Snowgoose Wildlife Trust

Re: THE 'SIR PETER SCOTT CENTENARY CENTRE', Your Ref:H18-0321-11 and H18-0320-11

Further to your email of the 21-6-2011 please find attached a complete and revised copy of our main plans 1/LH/11-rev2, 2/LH/11-rev2 and 3/LH/11-rev1.

Sir Peter Scott Centenary Centre
East Bank Lighthouse, Sutton Bridge
Drawing 1/lh/11
SCALE 1:50
Snowgoose Wildlife Trust 16/4/2011

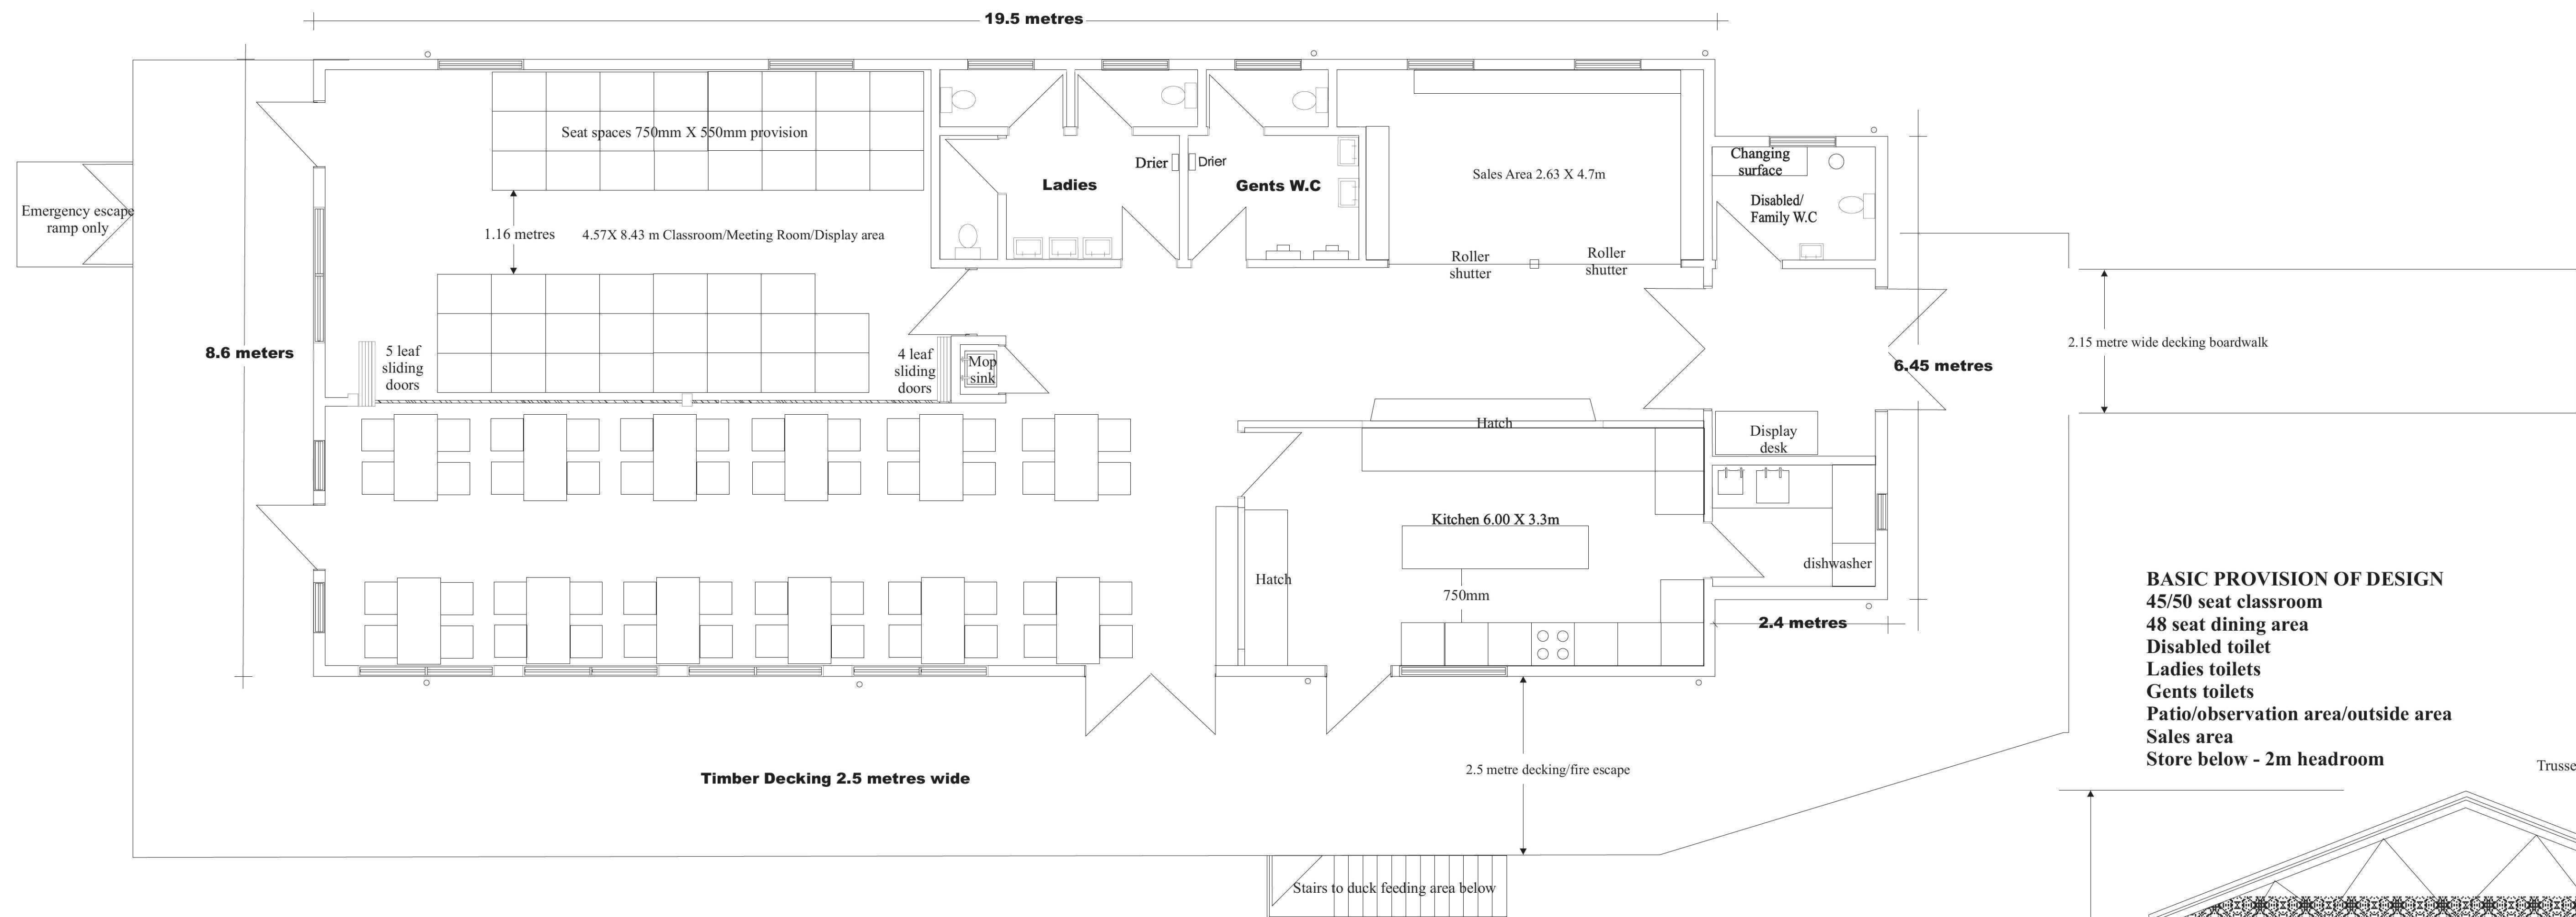
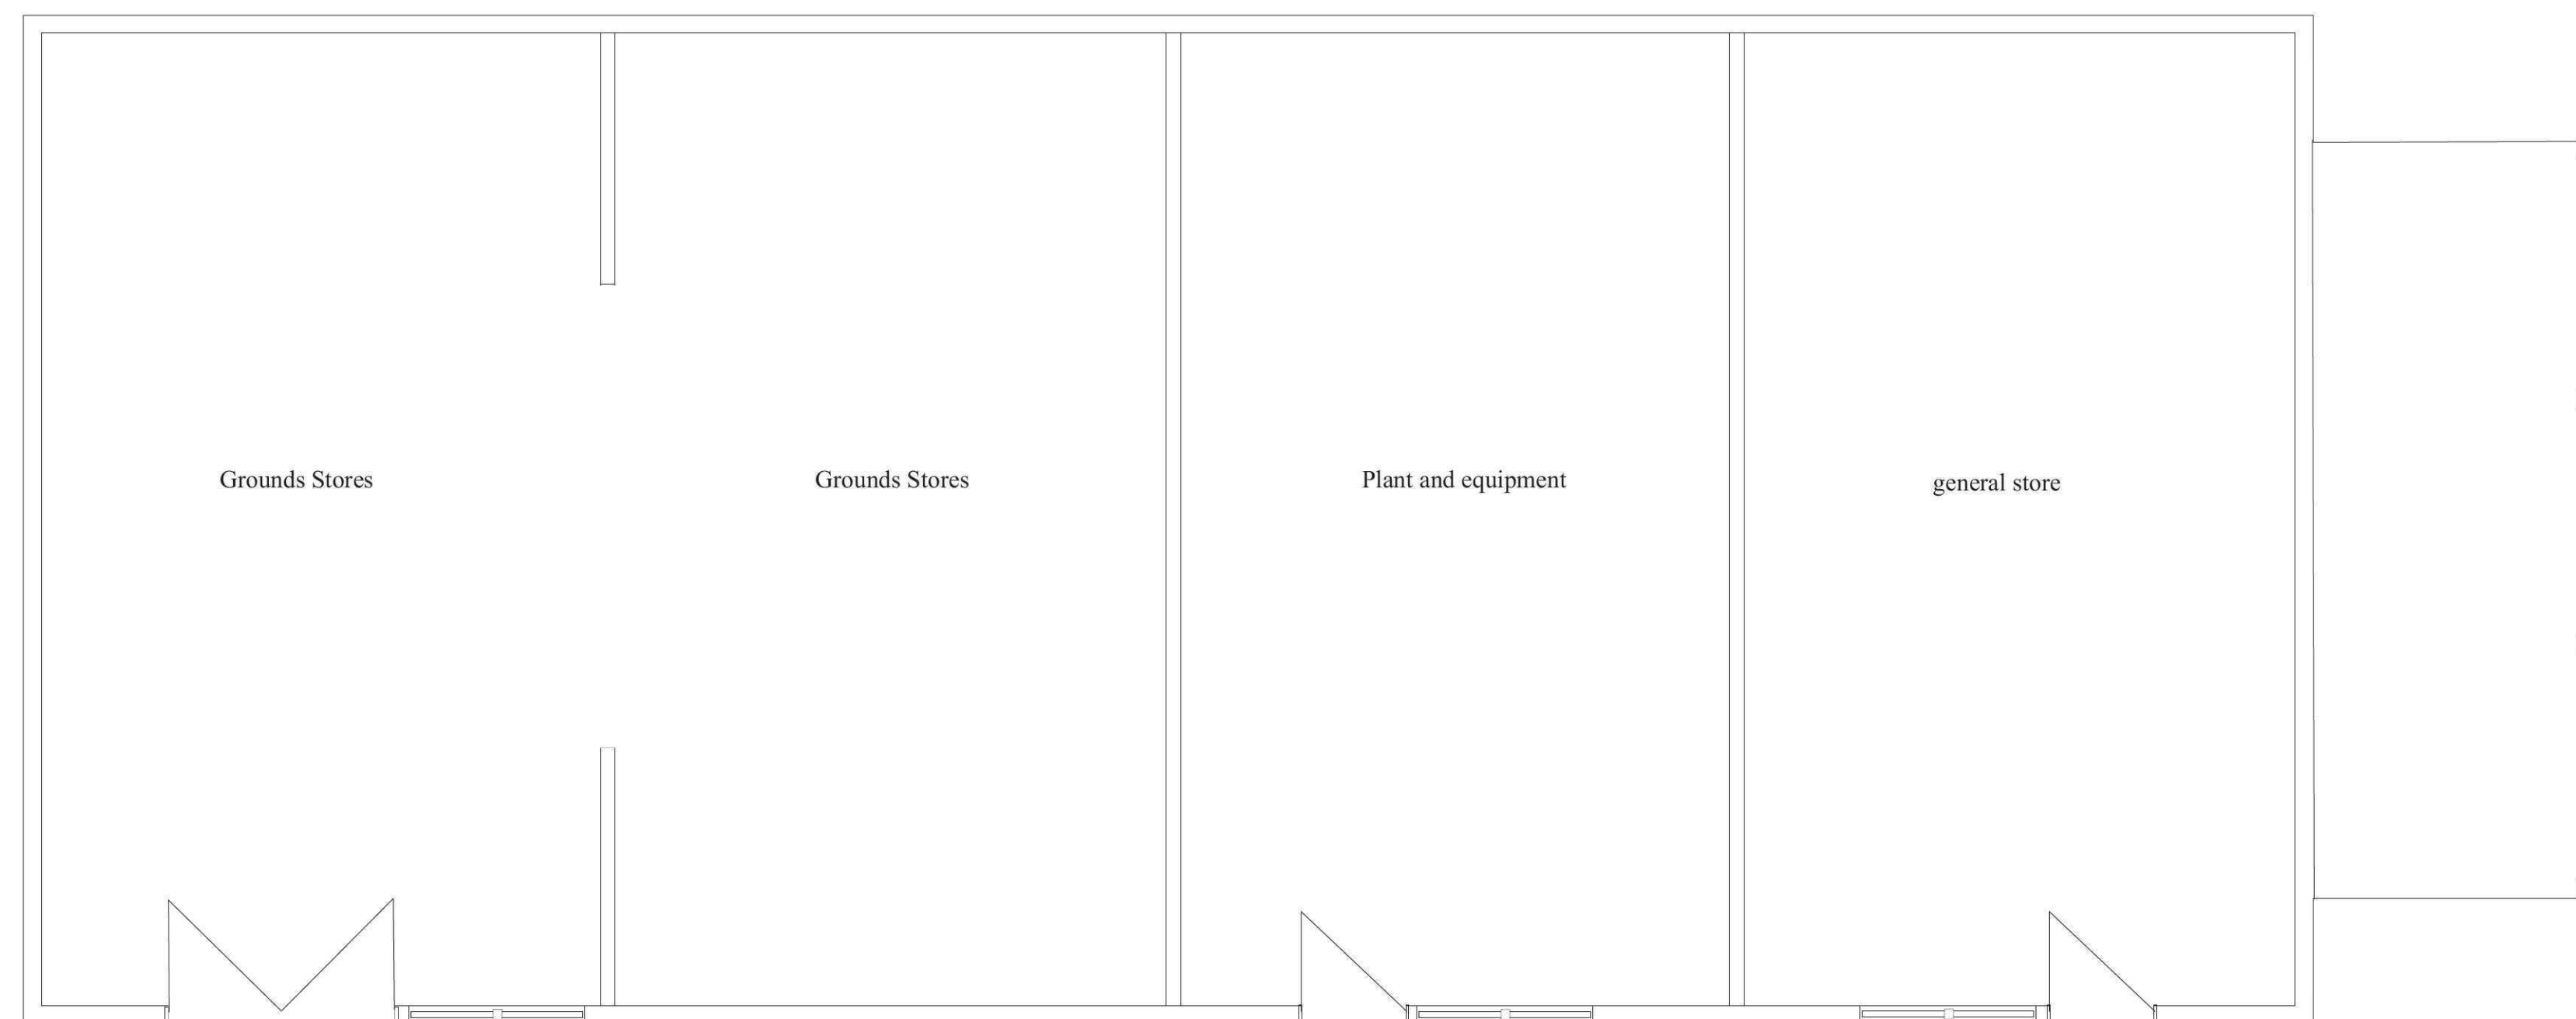
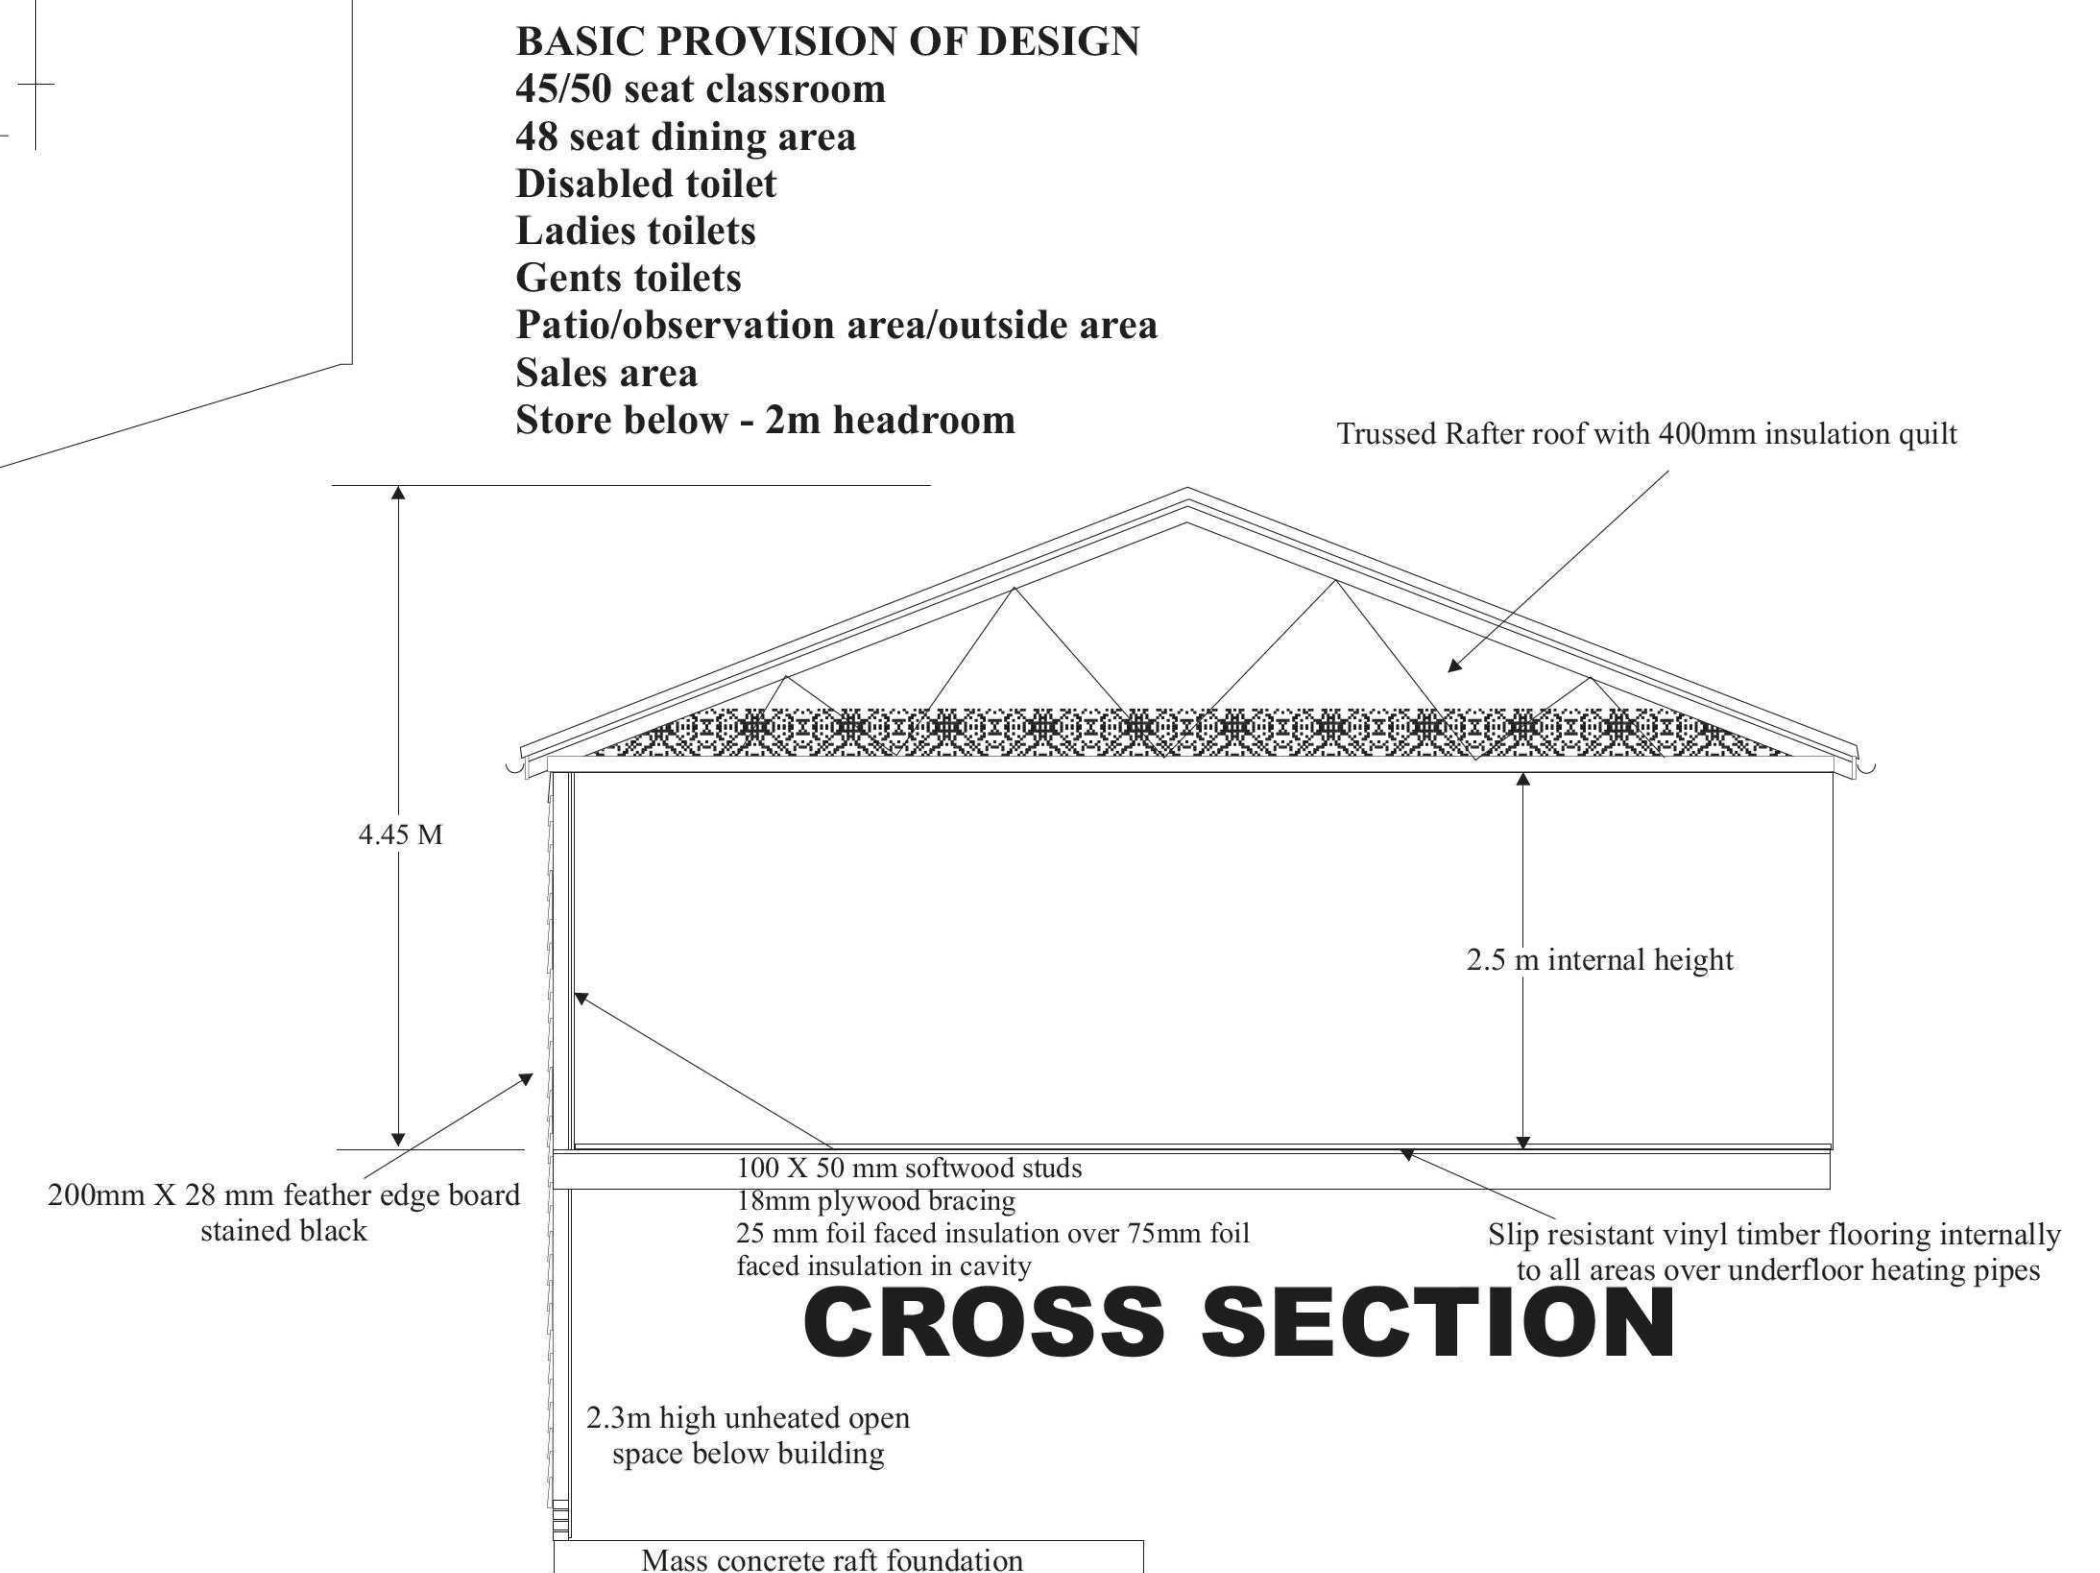
- (g) All external windows will be in nut brown and not white as previously.
- (h) **Listed trees** It is confirmed that the listed sycamore trees numbers one and ten as counted from the highway gate will now be retained.
